OXFORDSHIRE COUNTY COUNCIL'S RESPONSE TO CONSULTATION ON THE FOLLOWING DEVELOPMENT PROPOSAL

Application no: 21/04157/F

Proposal: Use of the site for the storage of operational vehicles, together with elevational and site alterations, associated parking, welfare facilities, vehicle barrier and associated infrastructure

Lead Local Flood Authority

Appendix D – Proposed Drainage Layout

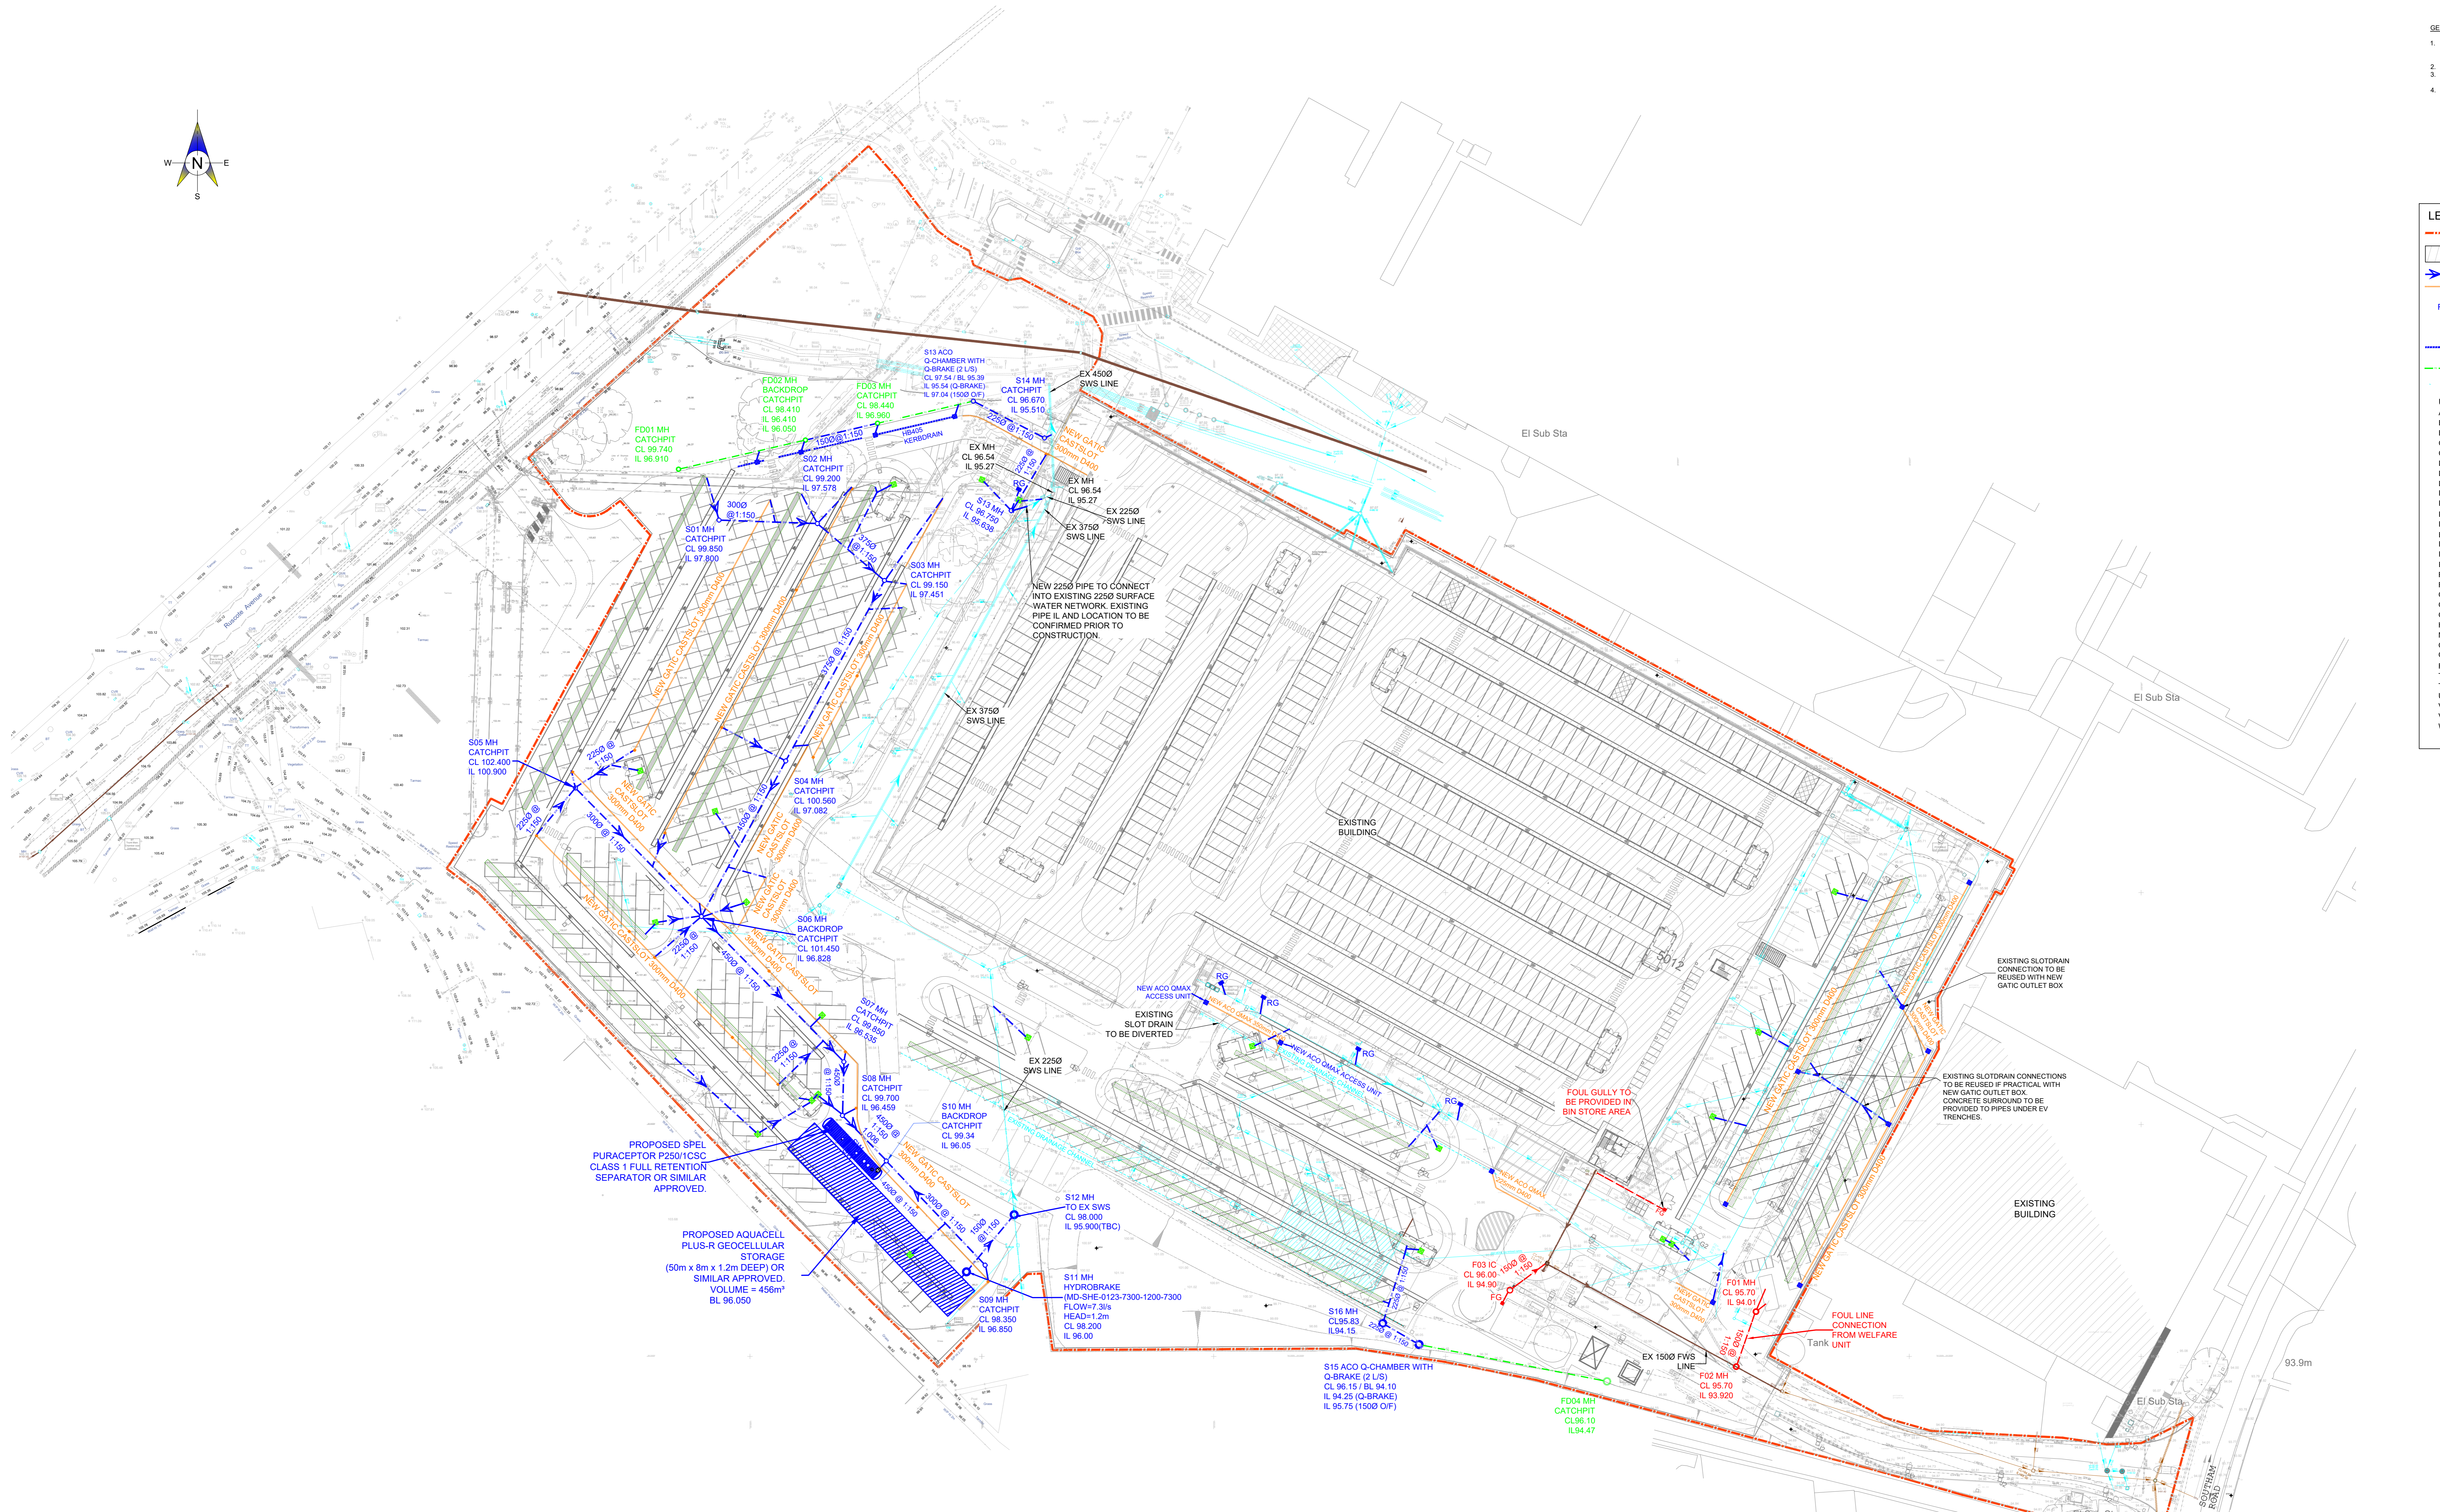
On the surface water drainage strategy drawing there is a long strip of grey hatching that picks up the surface water in the car parking areas. This drainage feature has not been identified on the key, please clarify what sort of drainage feature this is.
